DRB Application No.: 03-00302 (SBP)	Project # 1002507
Project Name: ALAMEDA BUS. PK LOT 43	EPC Application No.:
Agent: Sanders & Associates Architects	Phone No.: 842-8413

**CITY OF ALBUQUERQUE
PLANNING DEPARTMENT
Development Review Board
3/12/03 Comments**

Subject: Alameda Business Park, Lot 43/SBP

1 SITE PLAN
 SCALE: 1" = 10'-0"

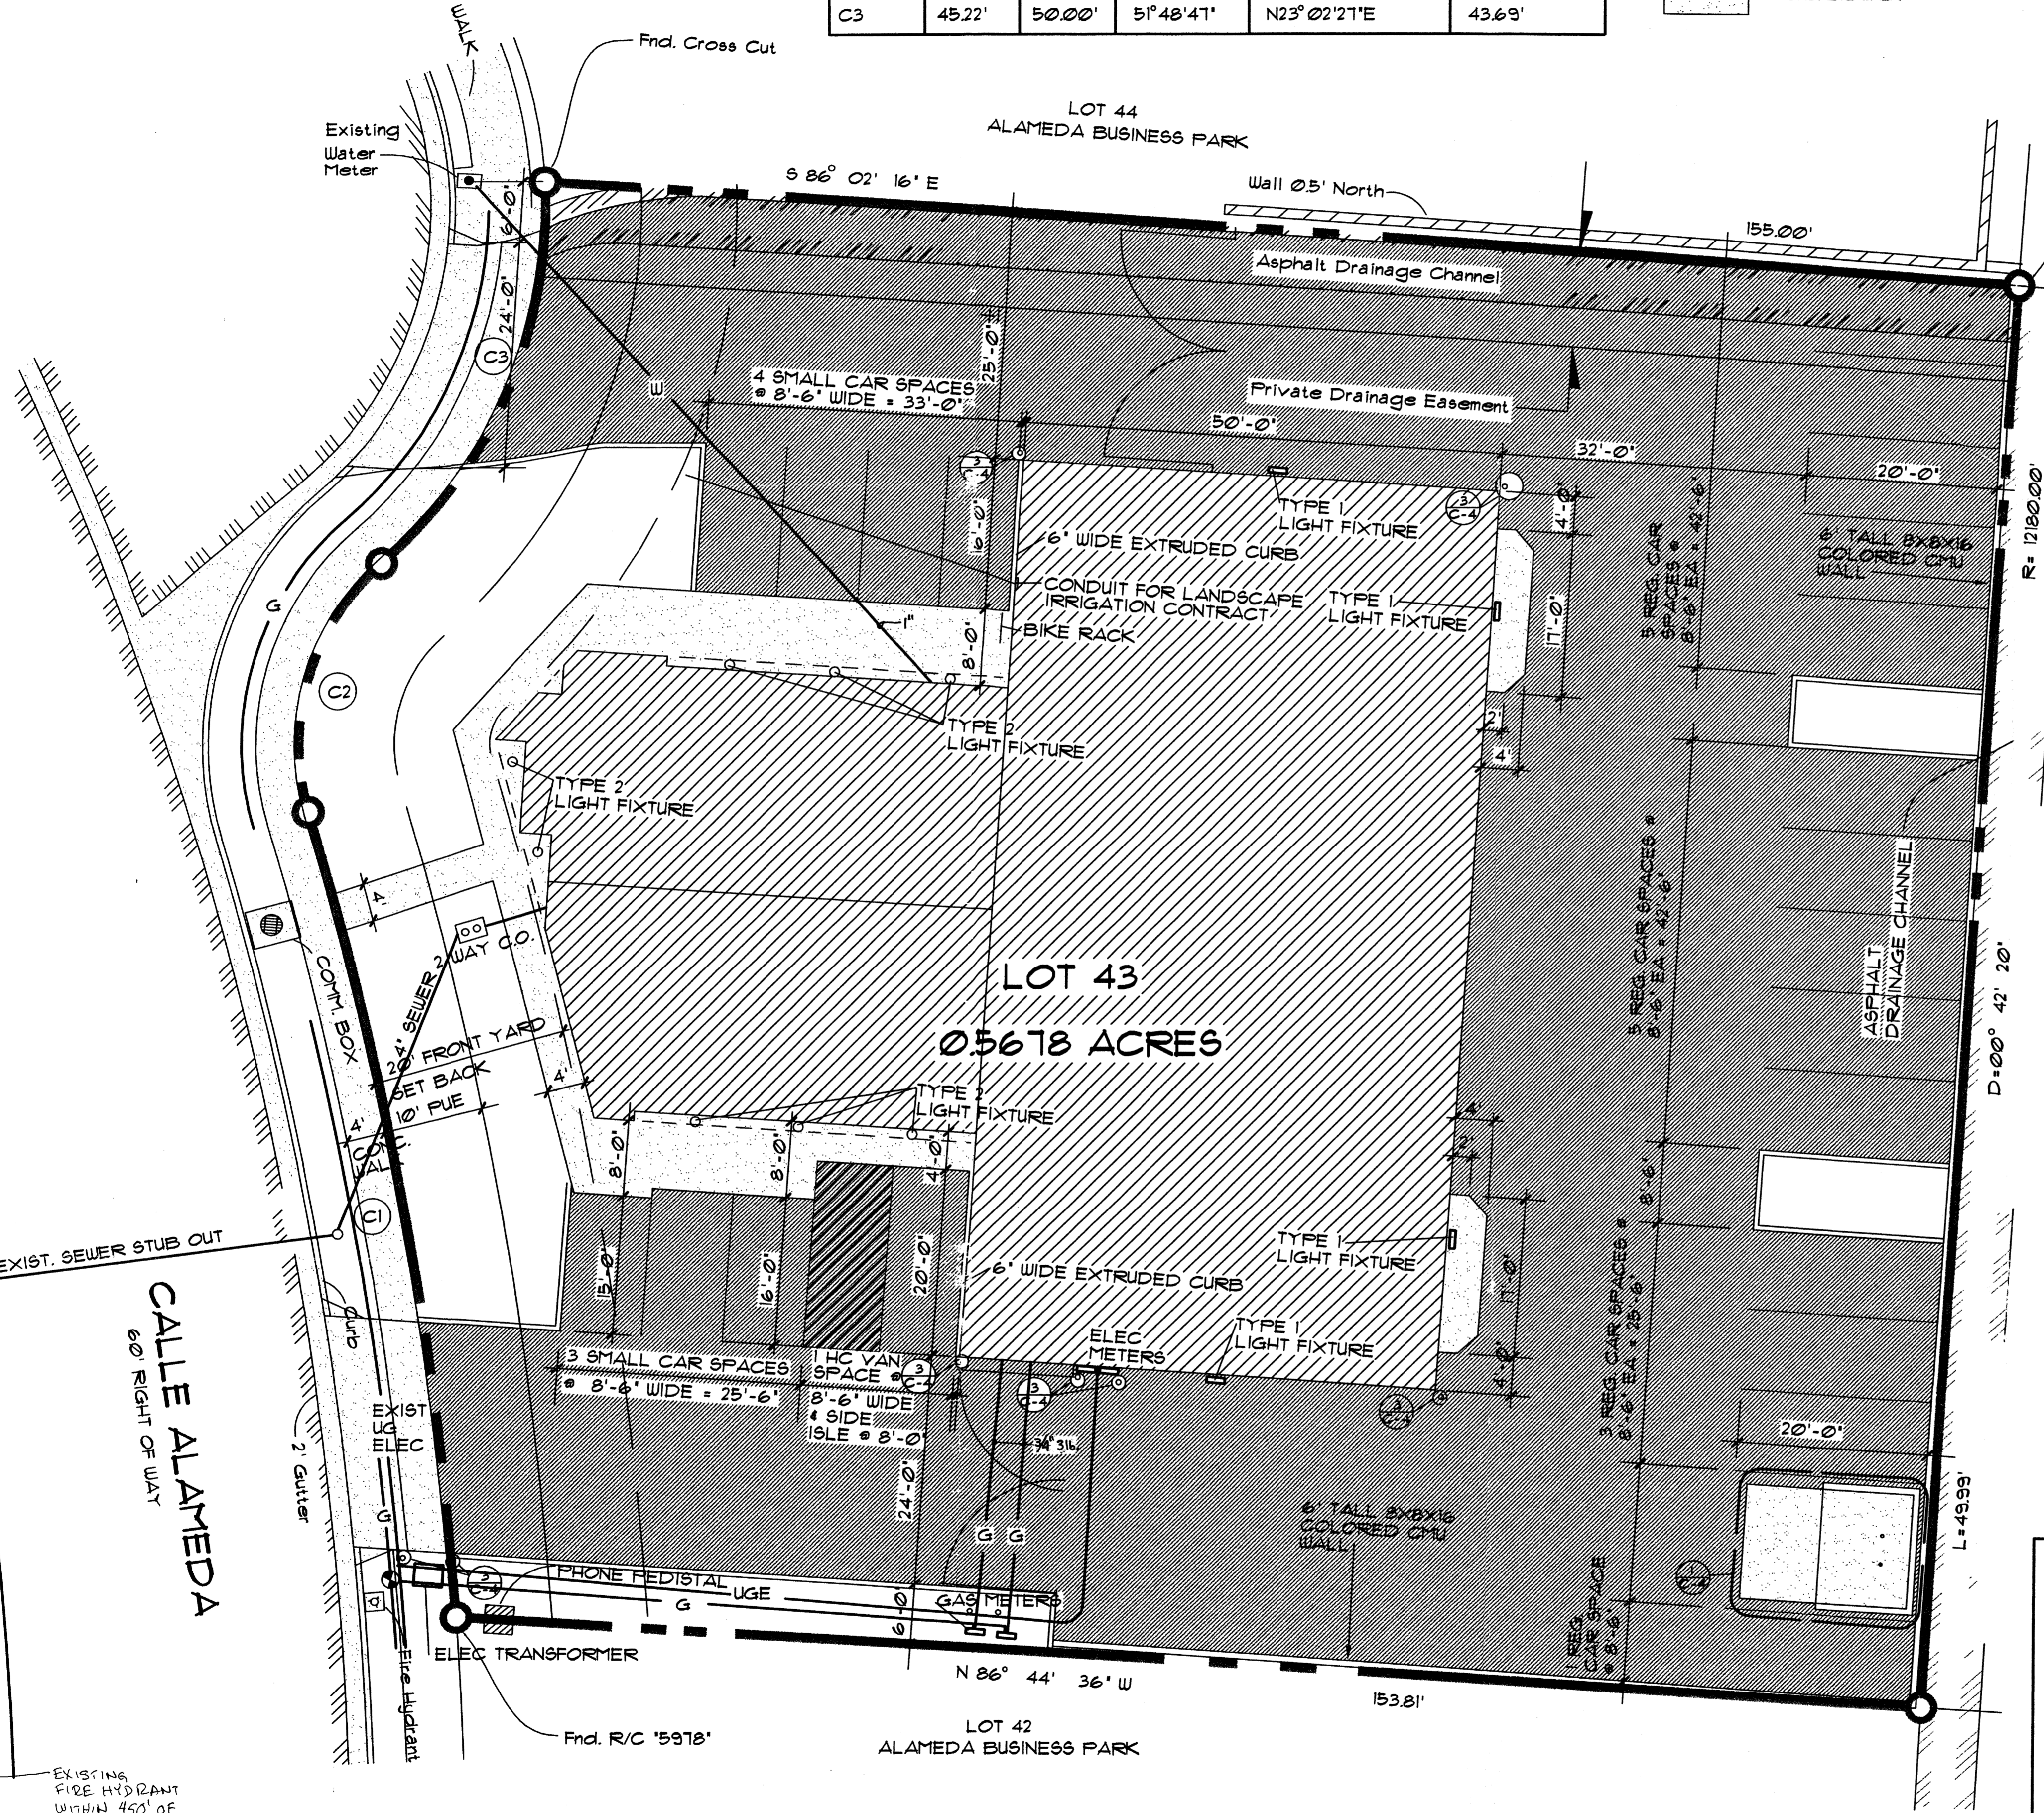
No.	Comment
<input type="checkbox"/>	How are deliveries to take place and not effect the use of the parking stalls?

The dumpster is not marked on the site plan.

The south side of the property should have a 6' landscape buffer all the way to the east property line. There is enough parking spaces to lose the one to the south of what we assume is the dumpster.

Signs are not shown on the elevations page or the site plan. Signs should be shown and conform to the Master Plan requirements.

1 SITE LANDSCAPING PLAN
SCALE: 1" = 10'-0"

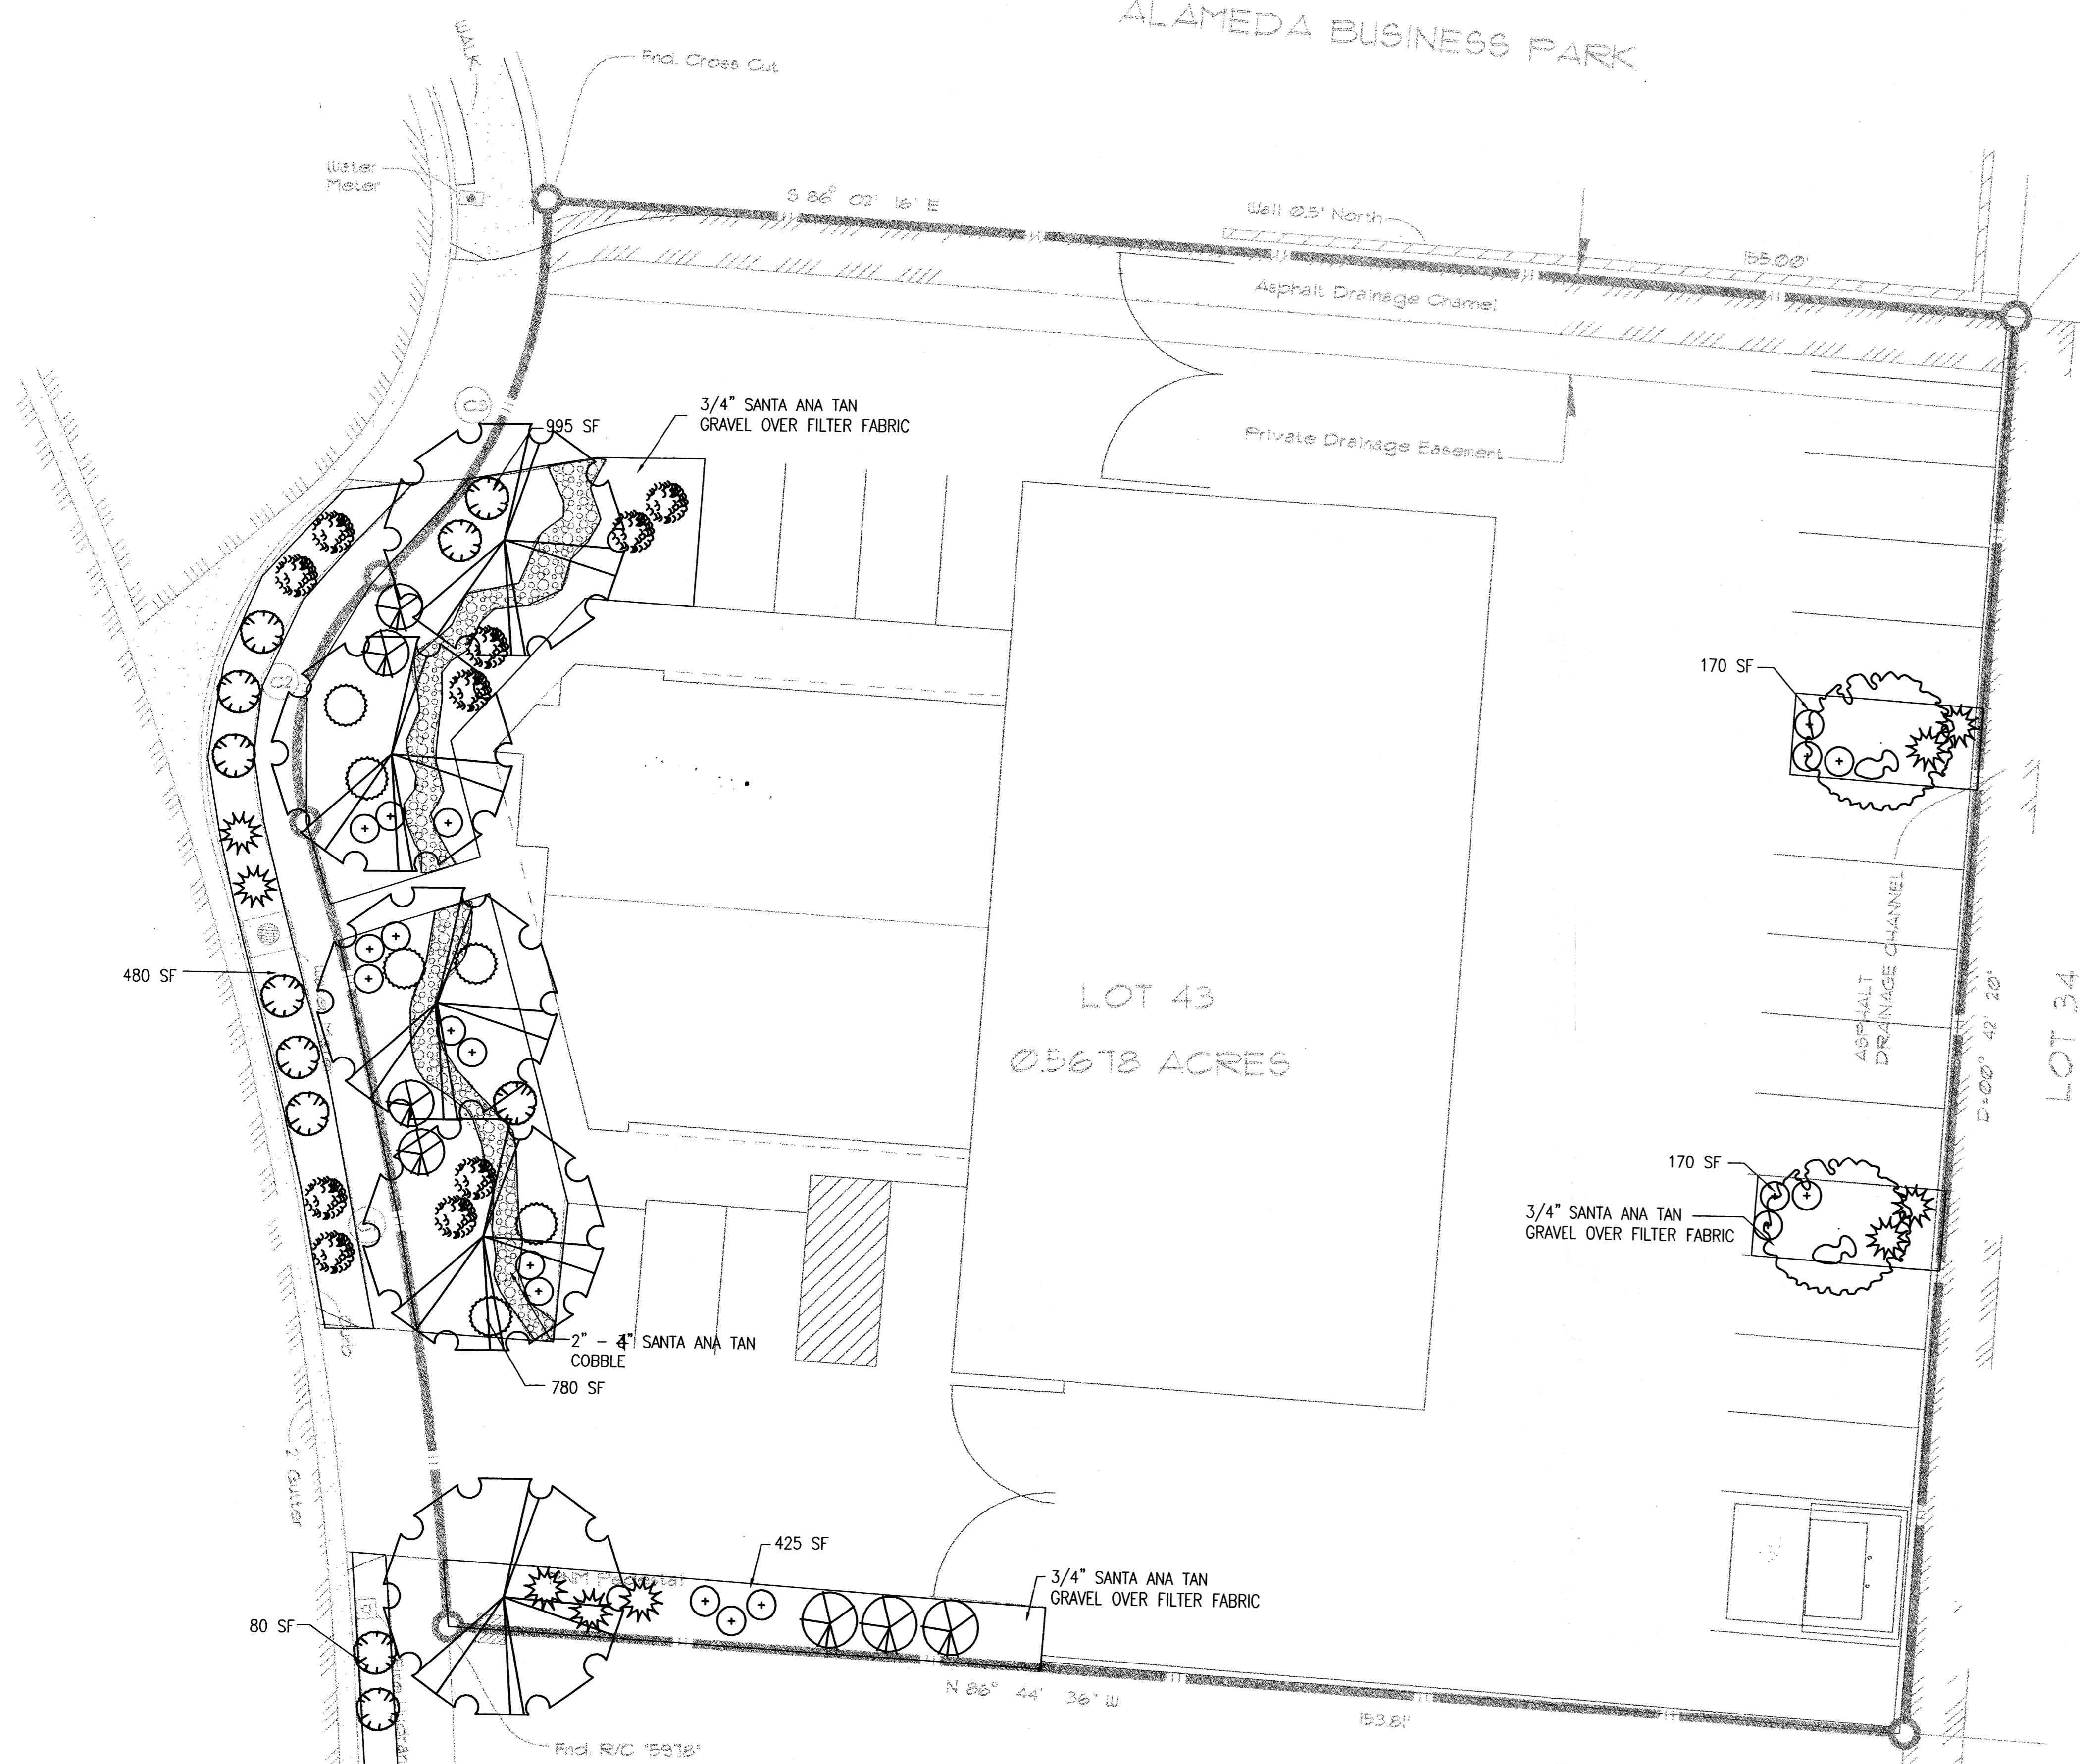
Not all of the plants & trees listed on the landscape plan conform to the plants & trees listed on the Master Plan as required by that plan.
